MINOR SITE PLAN DEVELOPMENT REVIEW

Final review and sign off

PROJECT: 72 Walnut St Application #: 2006-0230

Date of completion: 7/28/2009

FRONT ELEVATION

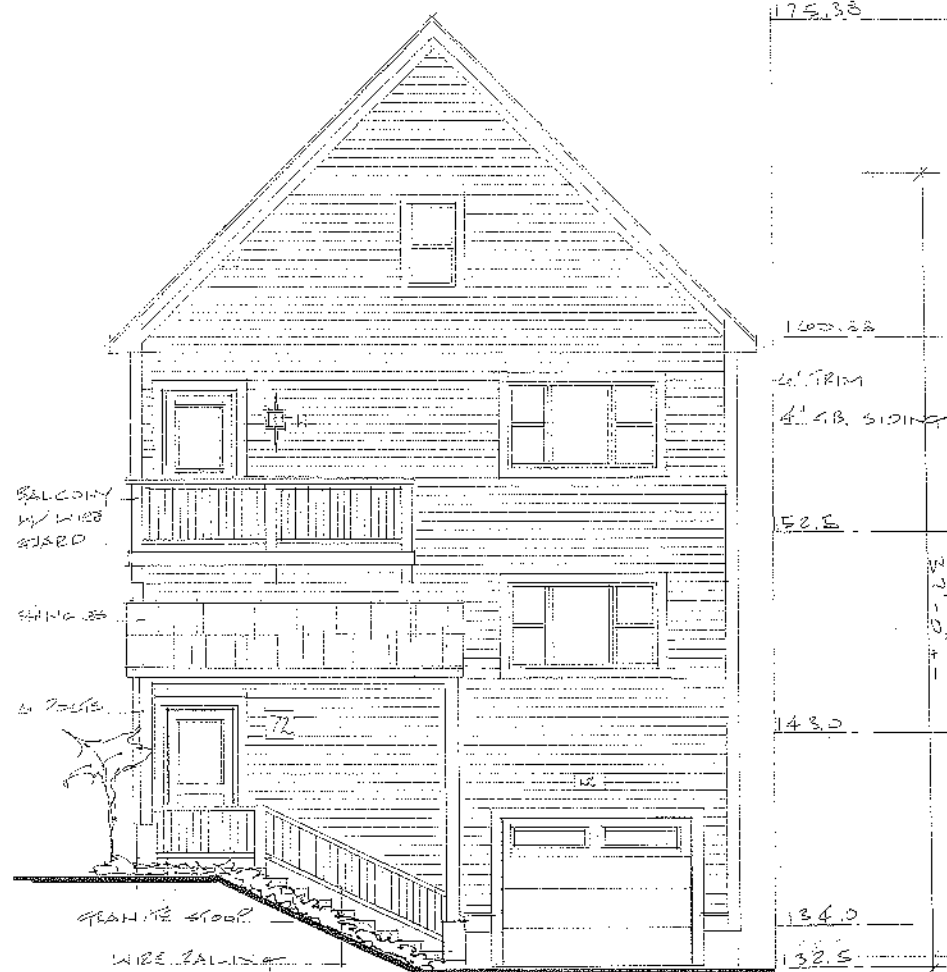
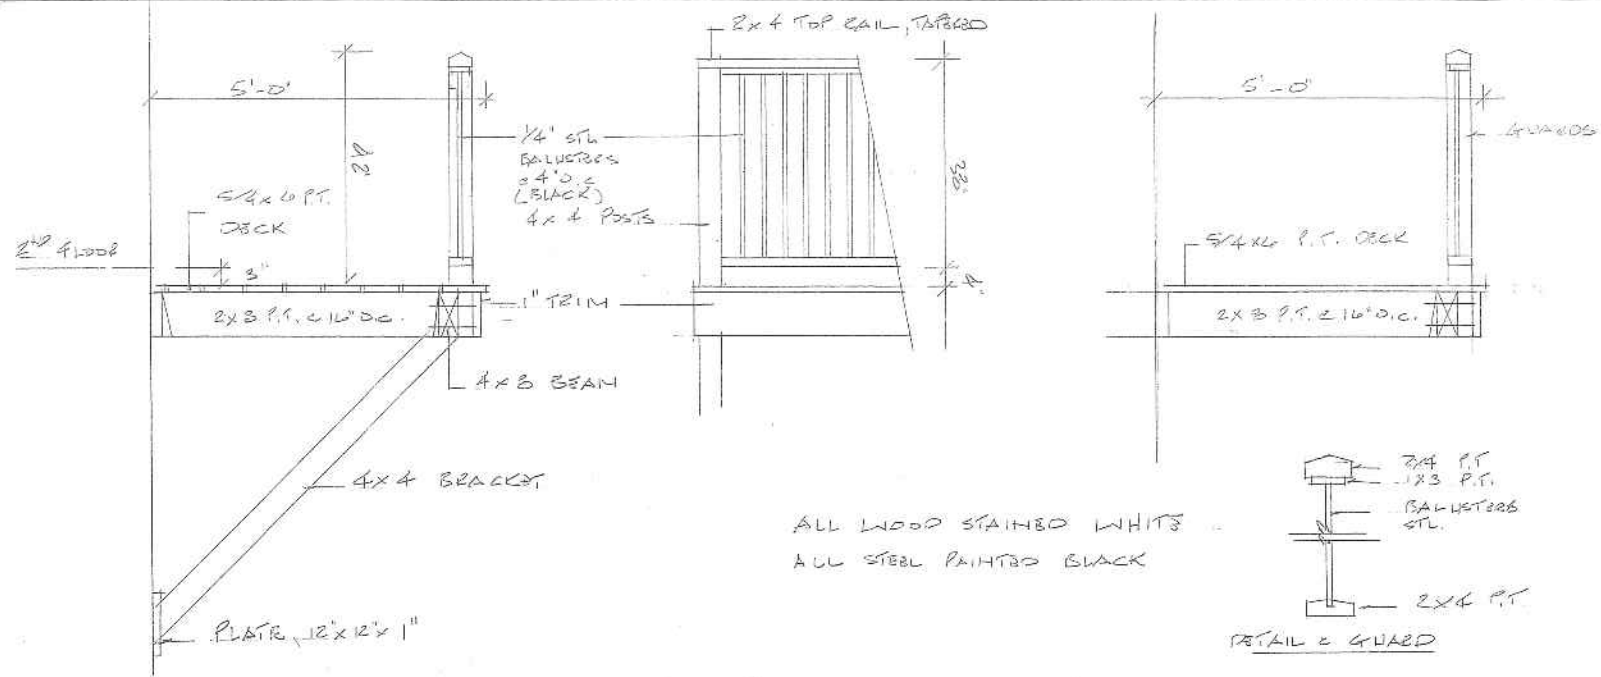
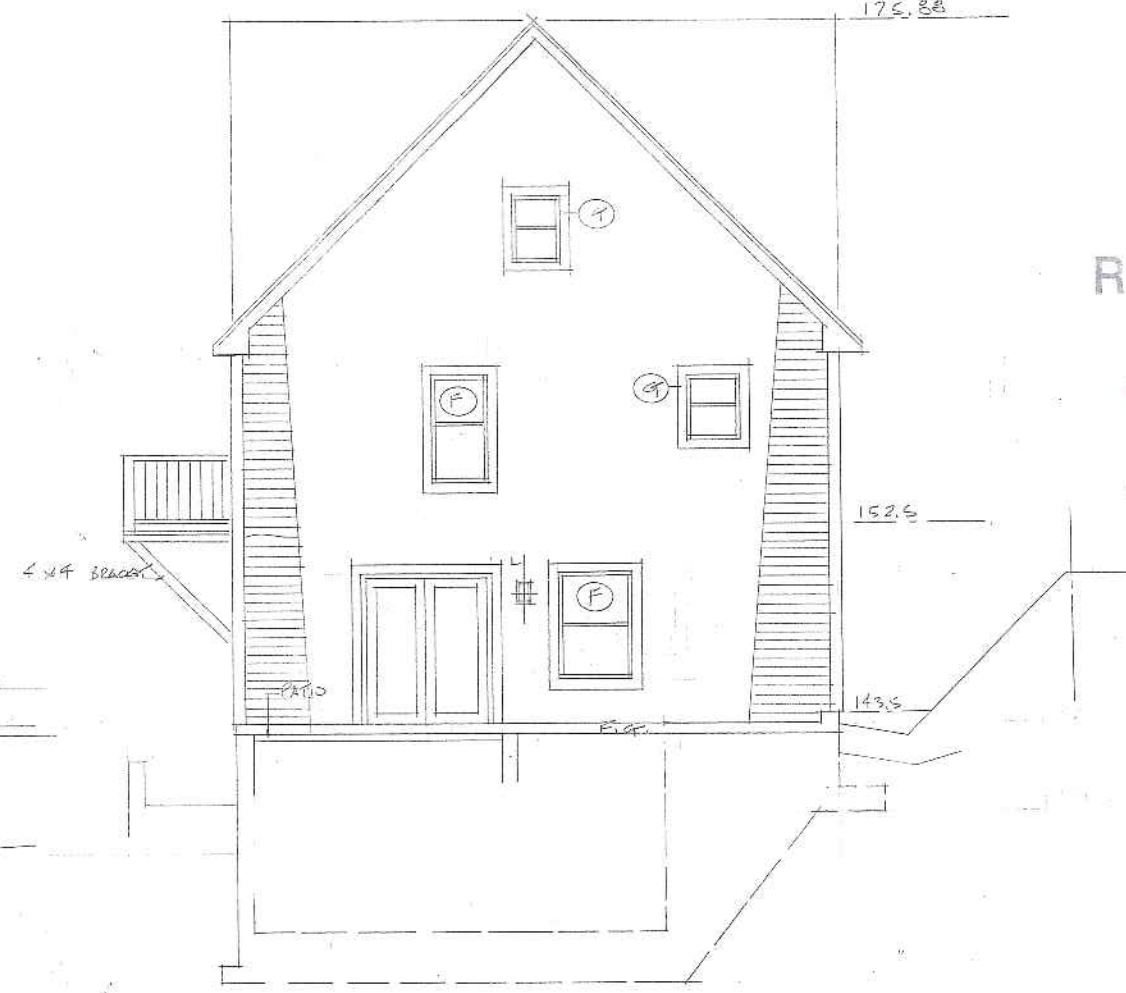
- ② Reg. HP under 14-526(18) - HP(OA) OK with proposal except a few details re windows + porch supports (these revised to address her concerns)
- ③ was reviewed under 14-526(28) Re uphill design Drains + Stds - see Design Review memo 7/28/09
